Your Ref: FG/33/18/PL
Date: 19th March 2018

**Re: Land at the former McIntyre Nursery, Littlehampton Road, West Sussex BN12 6PG
Demolition of polytunnels, use of land for Class B8 container self-storage and the
siting of 42 single-stacked storage containers, an office/toilet portacabin, new fencing,
gates, CCTV, lighting and alterations to the entrance.**

TITLE PROPOSED SITE & BLOCK PLAN	DWG NO 5285-2	REV C
--	-------------------------	-----------------

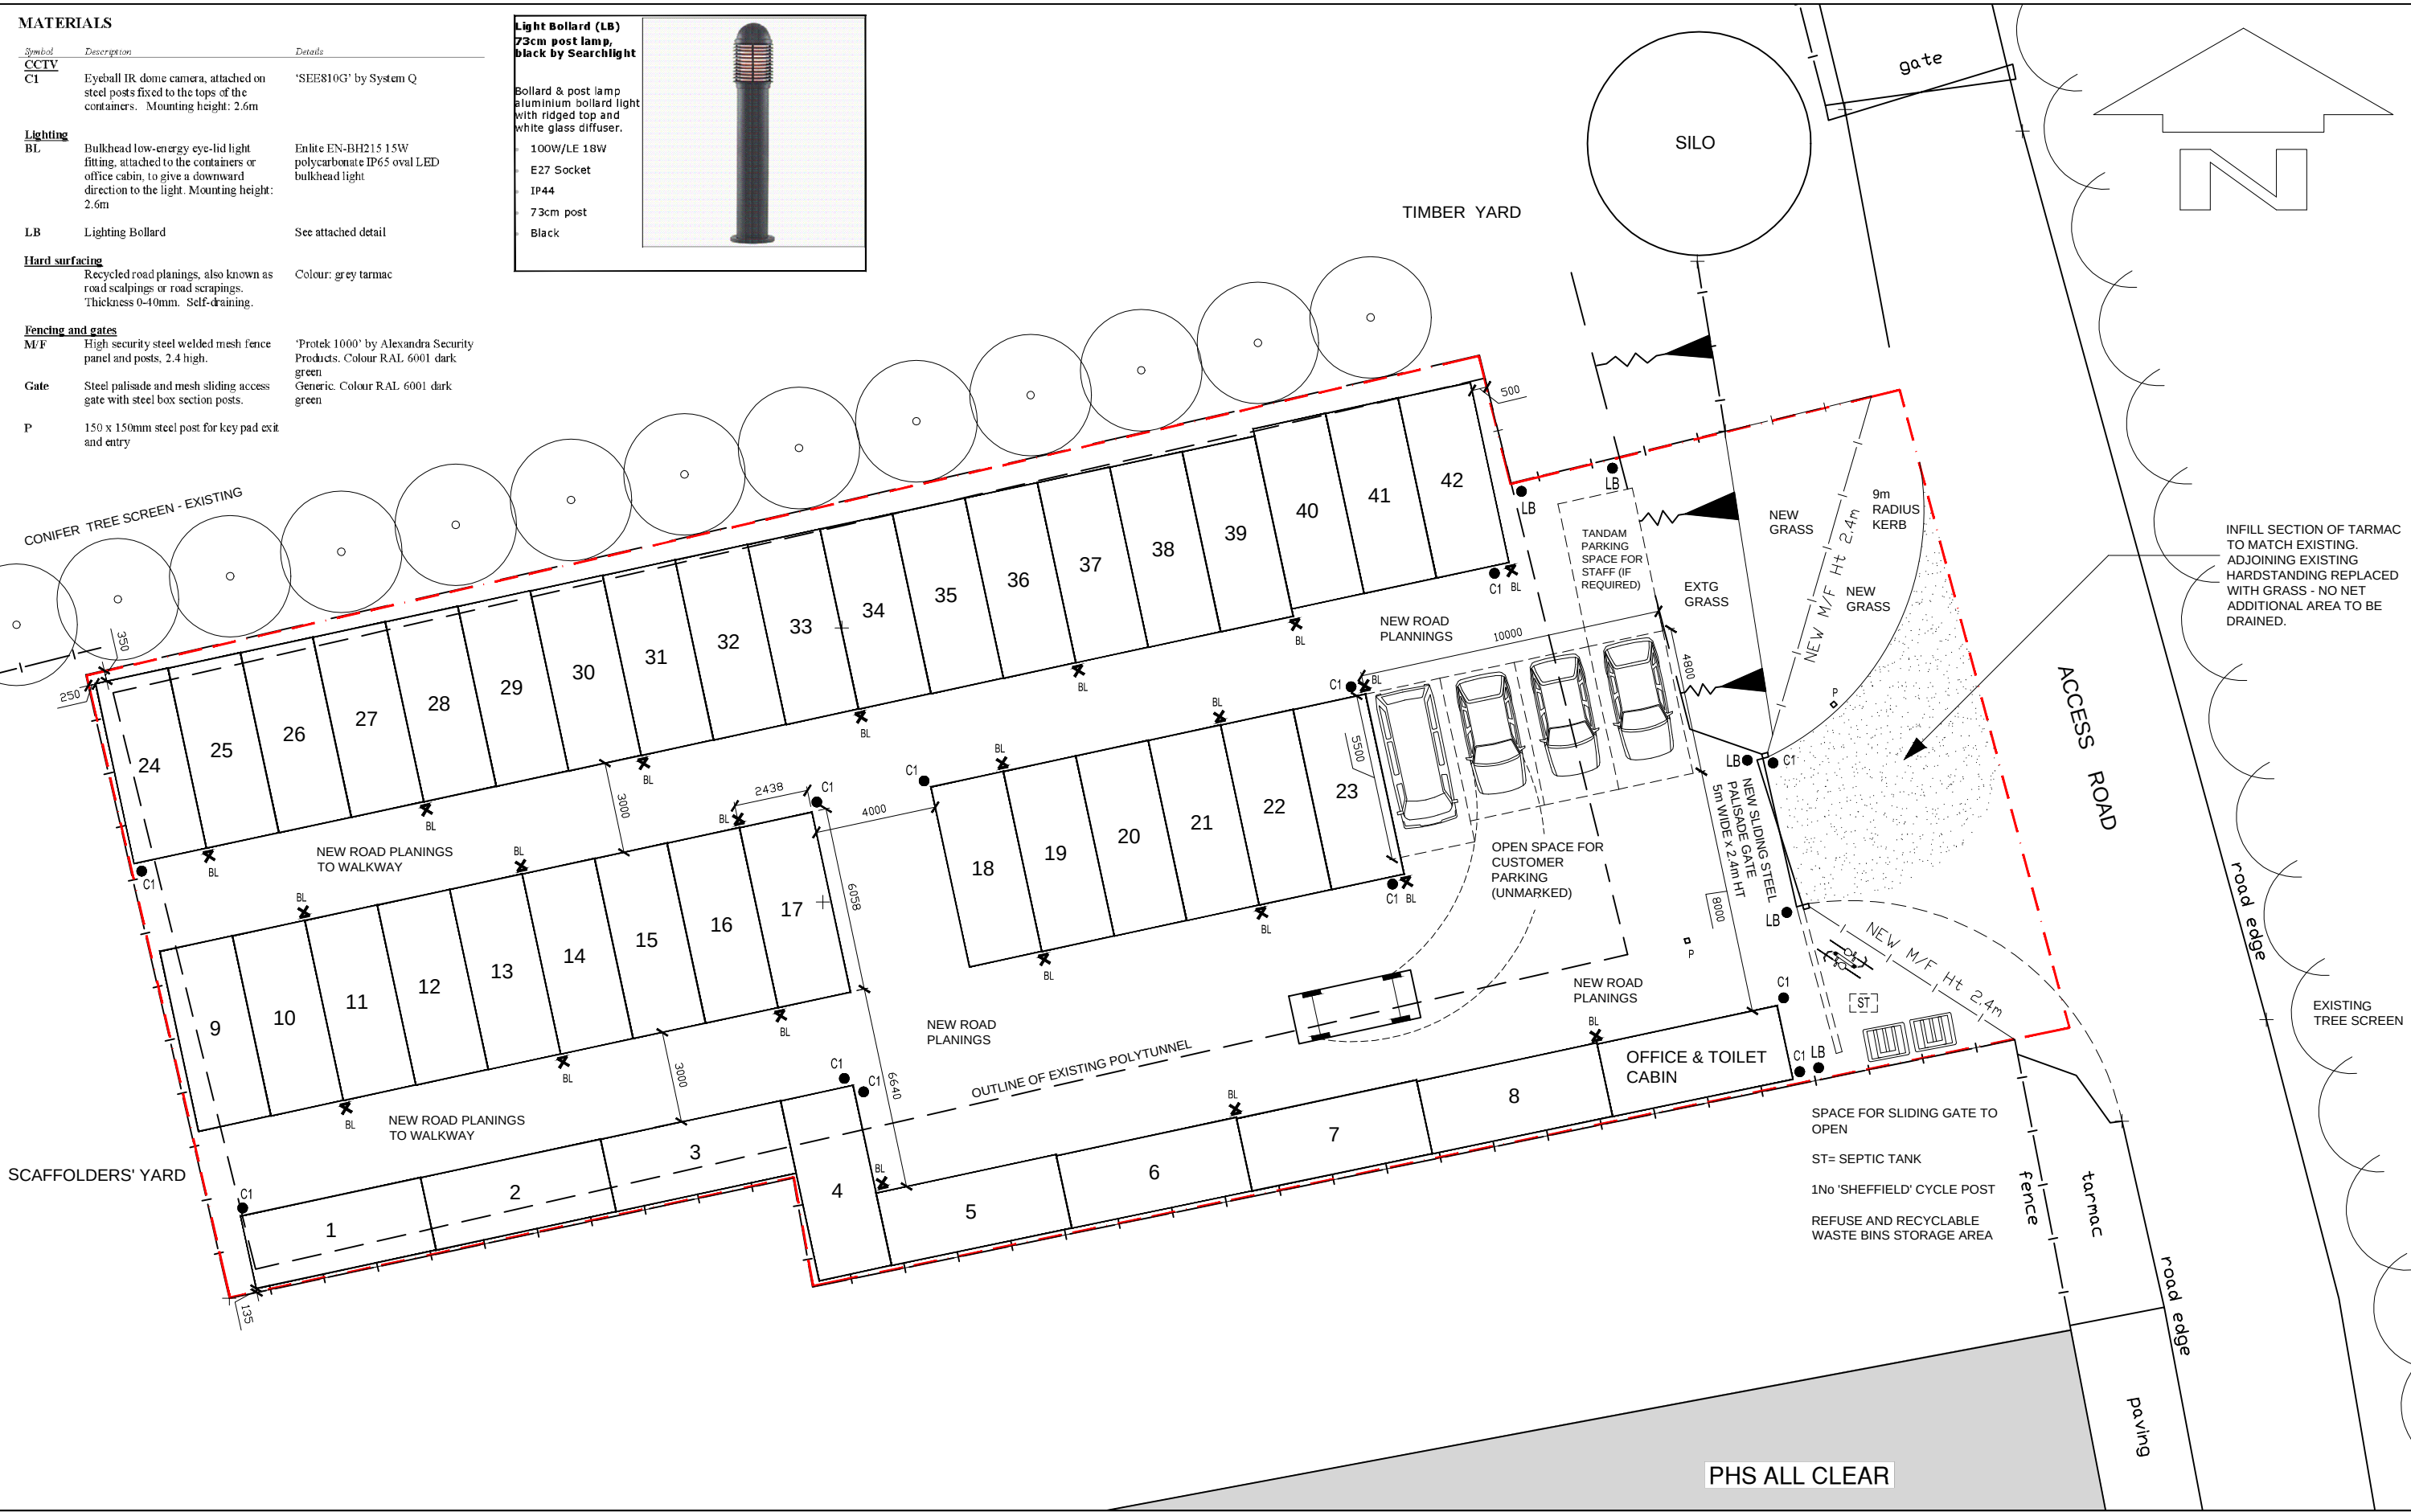
I note from the online Planning Register that the County Highway Authority have responded on the 14th March to the statutory consultation with a request for further information. Specifically, clarification of how the containers would be delivered and removed from the development site.

The applicant proposes to deliver (and eventually remove) the containers using a 7.5 ton flat-bed rigid lorry. This small lorry has a 20' loadspace, sufficient to accommodate a standard 20' shipping container (6.06 x 2.11m). A small mobile crane would manoeuvre the container into the required position.

It is proposed to reconfigure the site entrance in order to improve access for a 7.5T flat-bed. The proposed site plan shows a 9m radius hammerhead entrance. The container delivery lorry would perform a reverse side turn into the site from the main access road and eventually exit the site in forward motion. The 9m radius turning circle and 6.11m width of the access road conform with, or exceed, standard highway geometry, rendering a swept path analysis superfluous. The new access point would also offer improved sight lines.
